I'm not aware of what might still be needed for your site plan conditions of approval, but I think I have gone through all our email transactions with revisions and information and have a final list of items, if you could please address the following:

Subject: Re: 93 Washington-Container Project

Sheet
S1.1

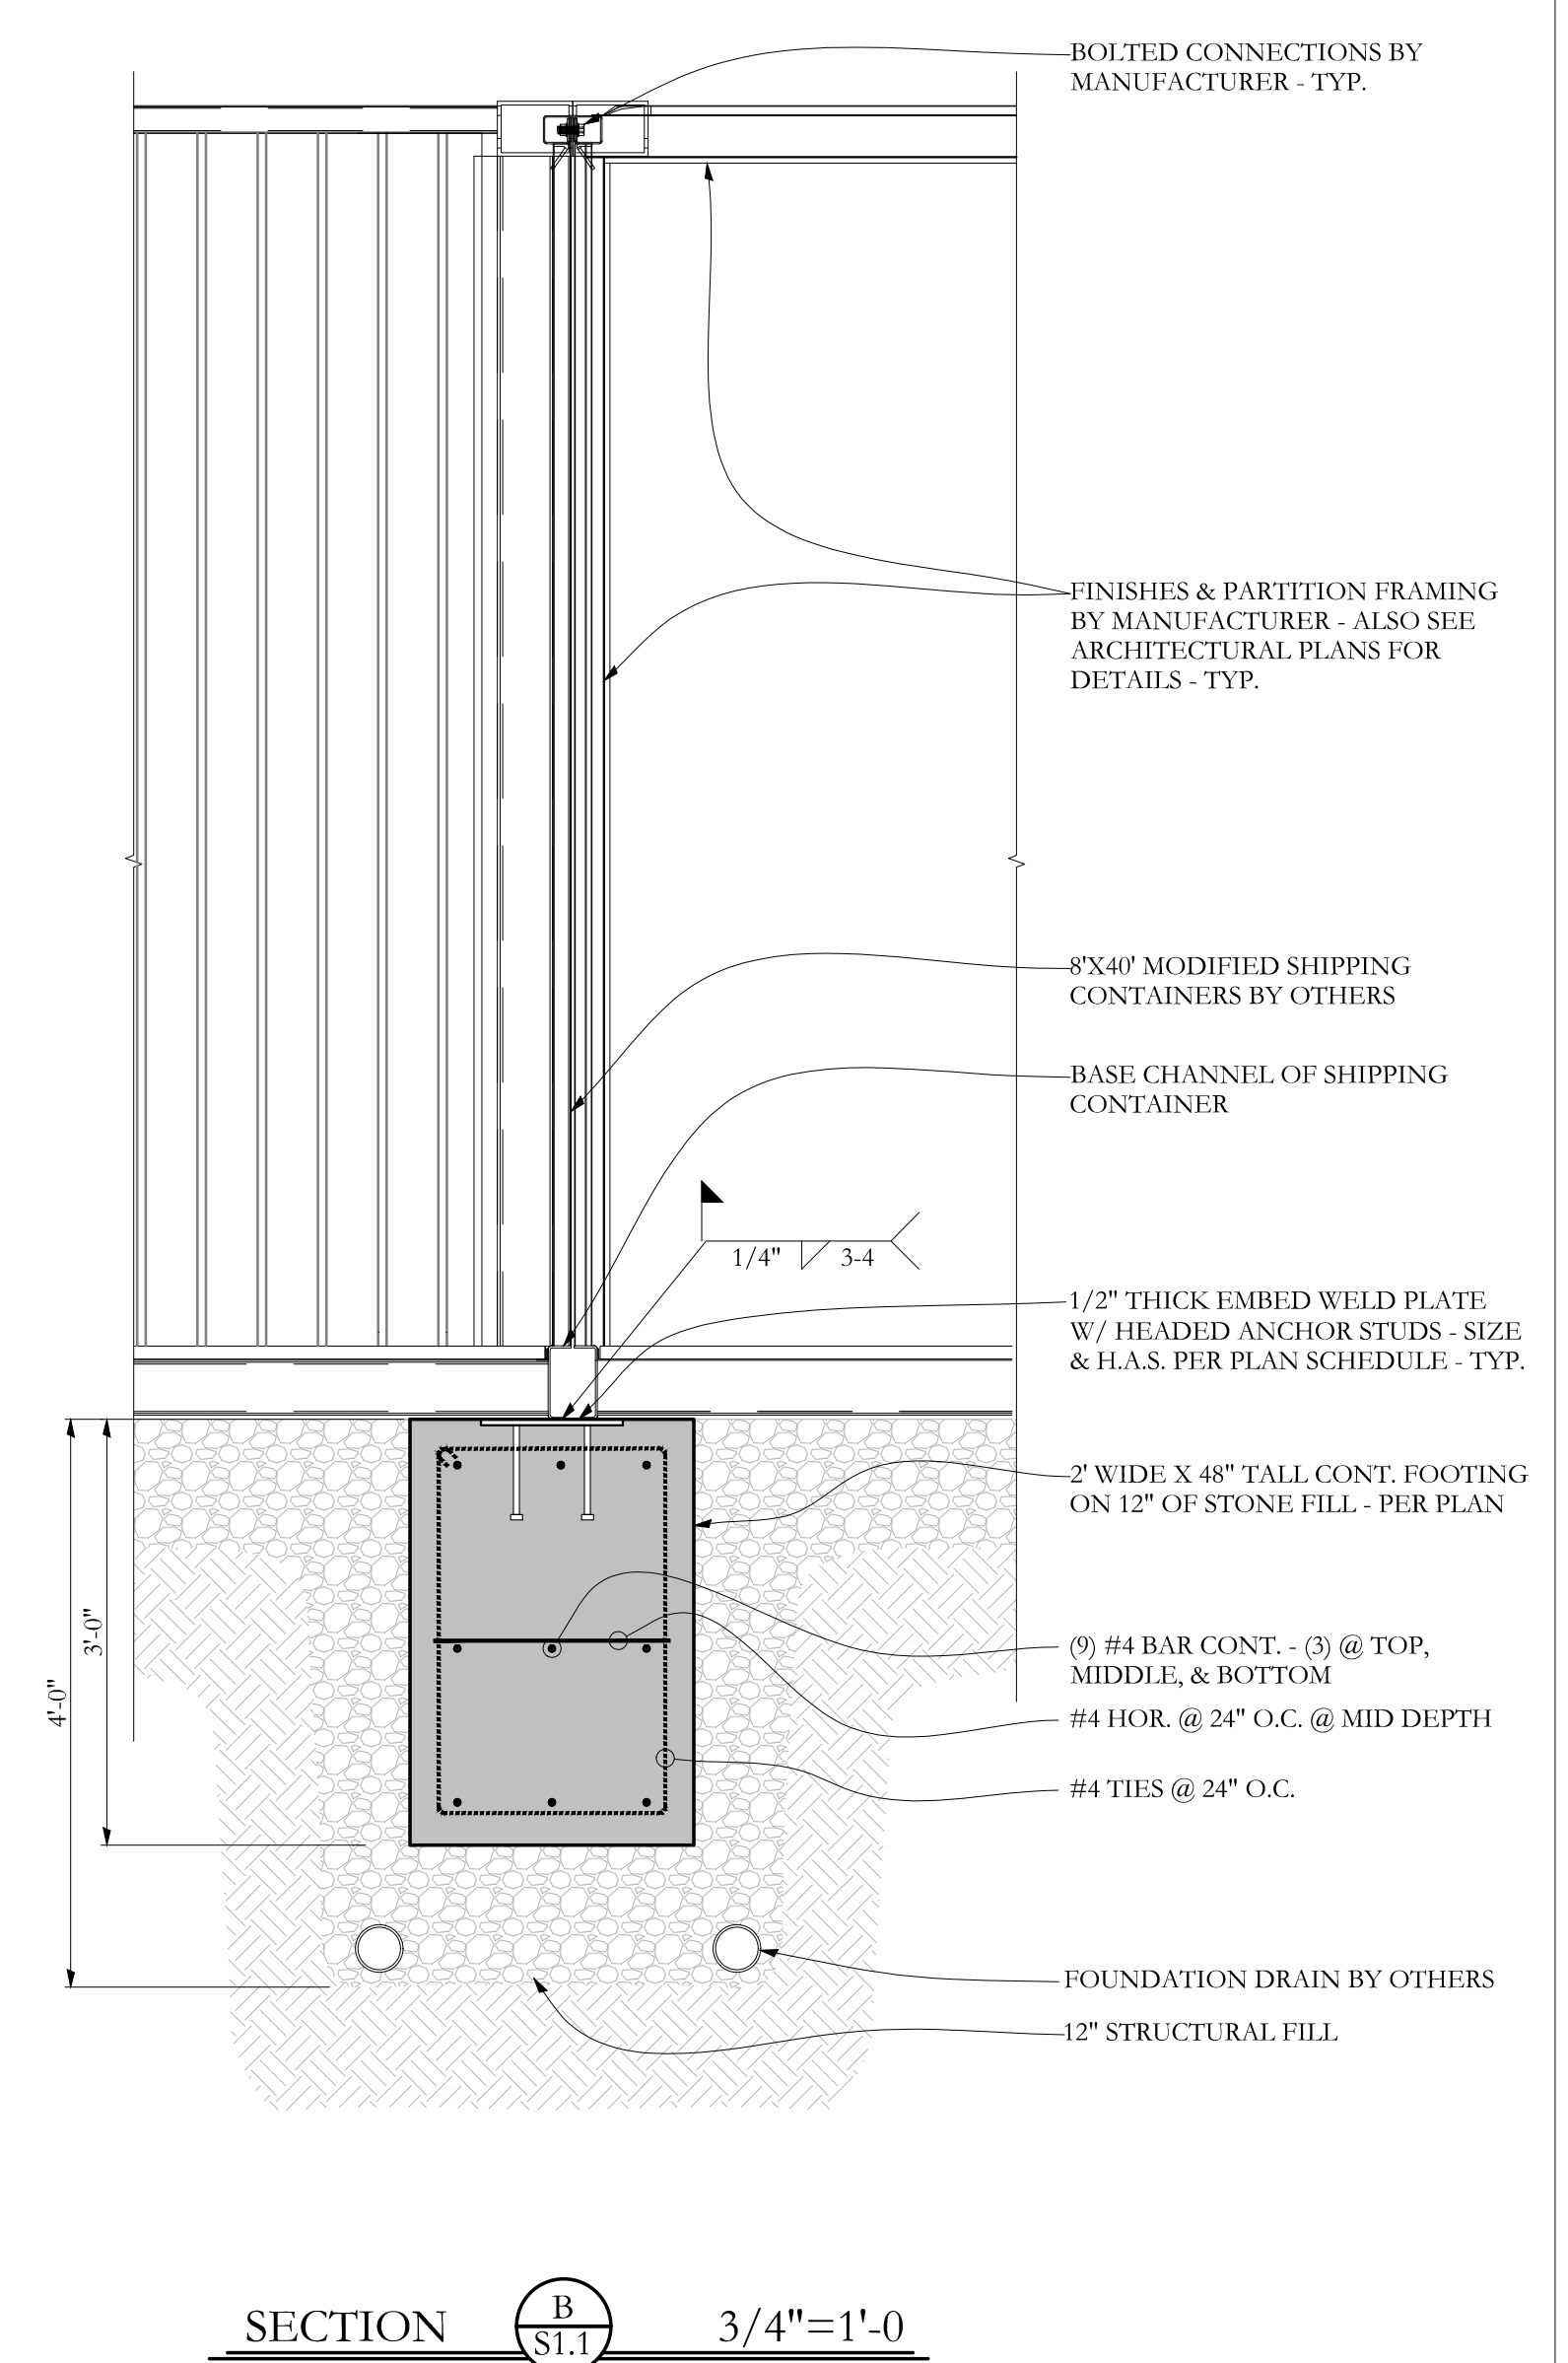
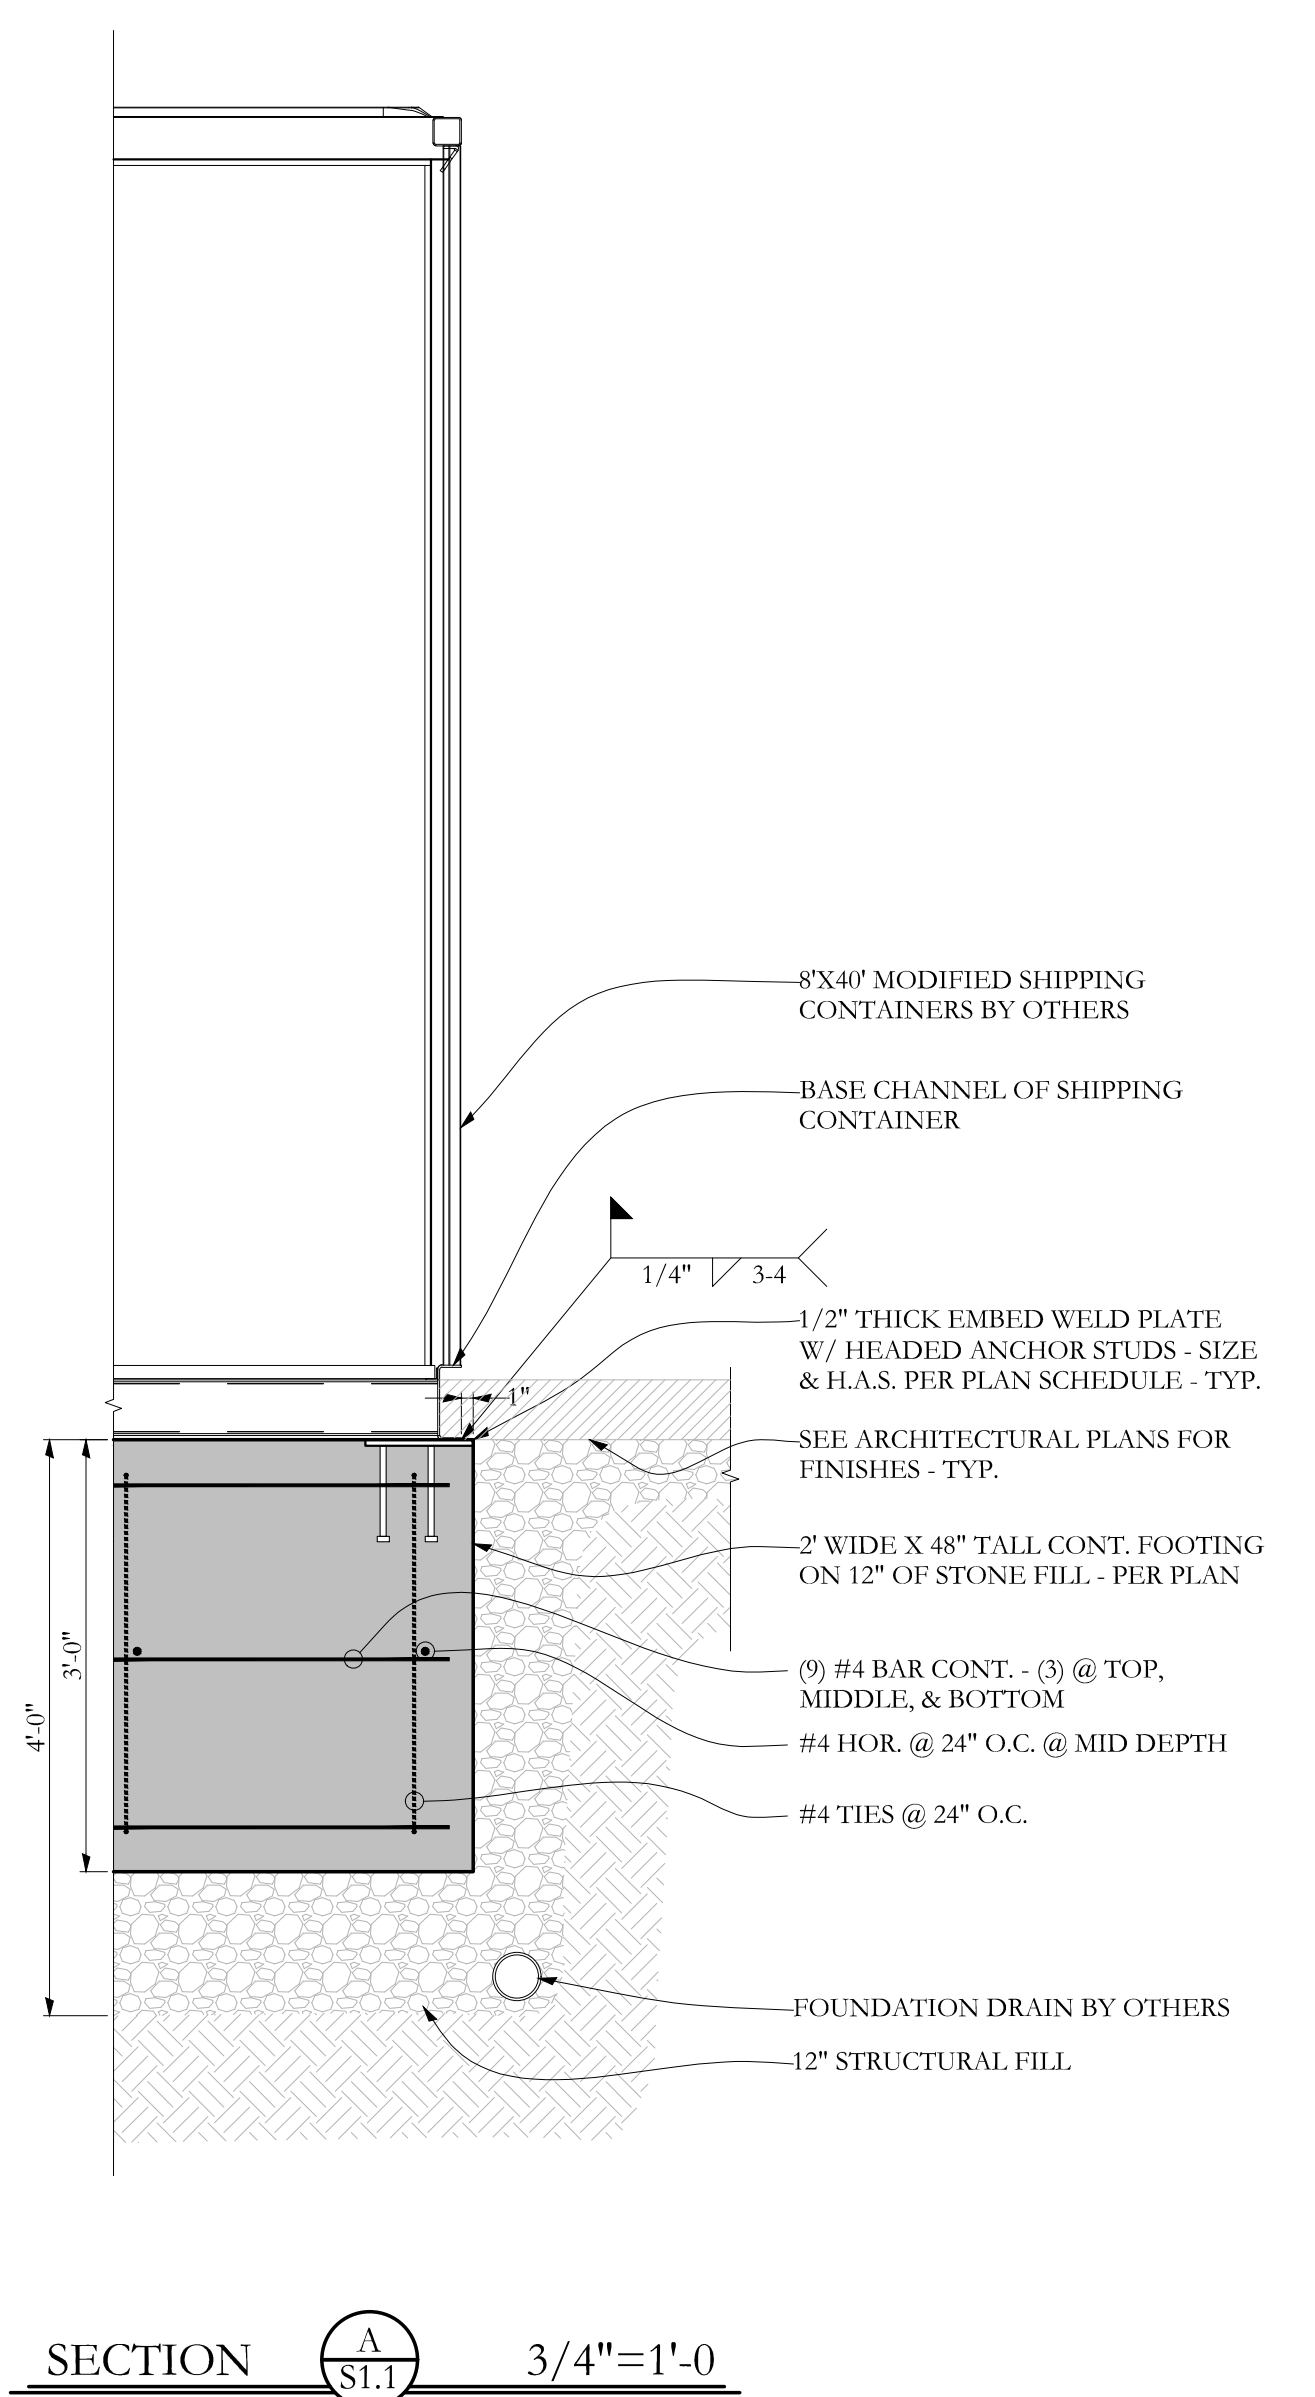
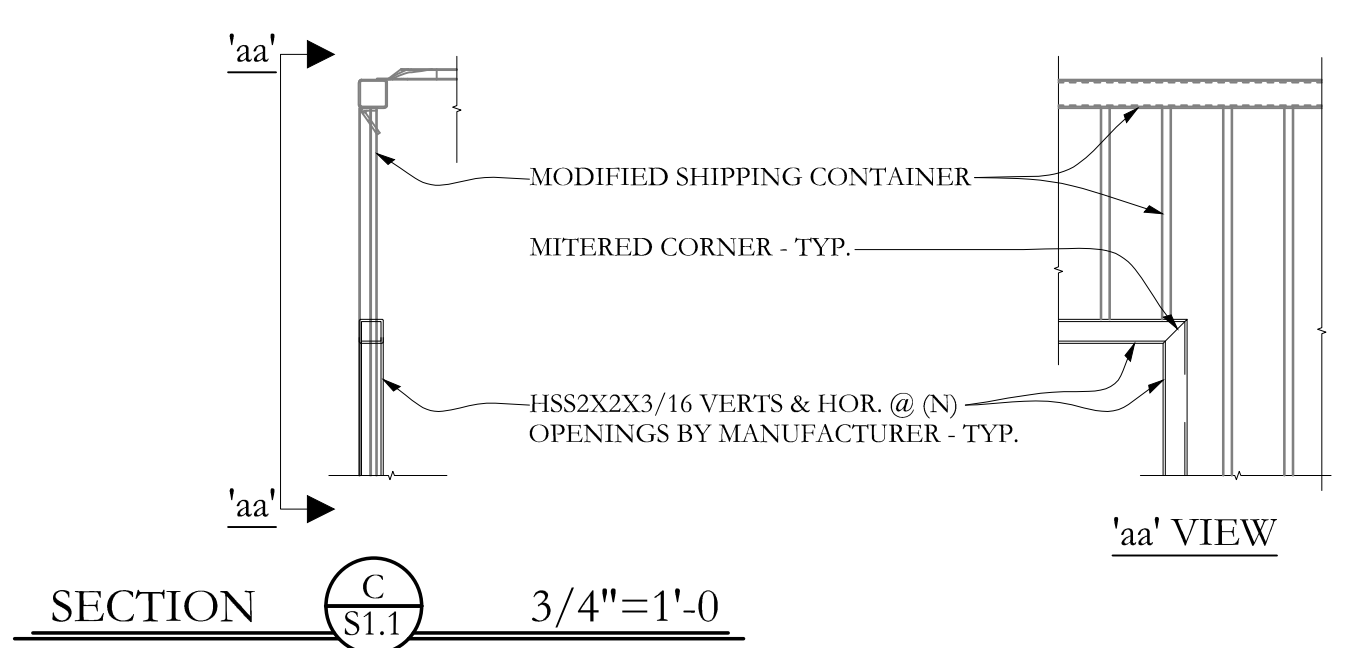
1. A letter with your intentions to follow Option 2 of the Shipping Container and Change of Use Policy, see attached. Itemize your acceptance and adherence with all 6 criteria. Include specific details and documents as per the requirements of #1 for the TPI inspections process, if applicable, and #4 for the submittal of a Statement of Special Inspections per IBC Chapter 17, and as noted on Plan S1.1
2. A detail for the bolted connections at the top of the container as noted on Plan S1.1 detail B to be per the manufacturer, see attached.
3. Details on plans for the construction of the parapet container, has the structural engineer reviewed this addition?
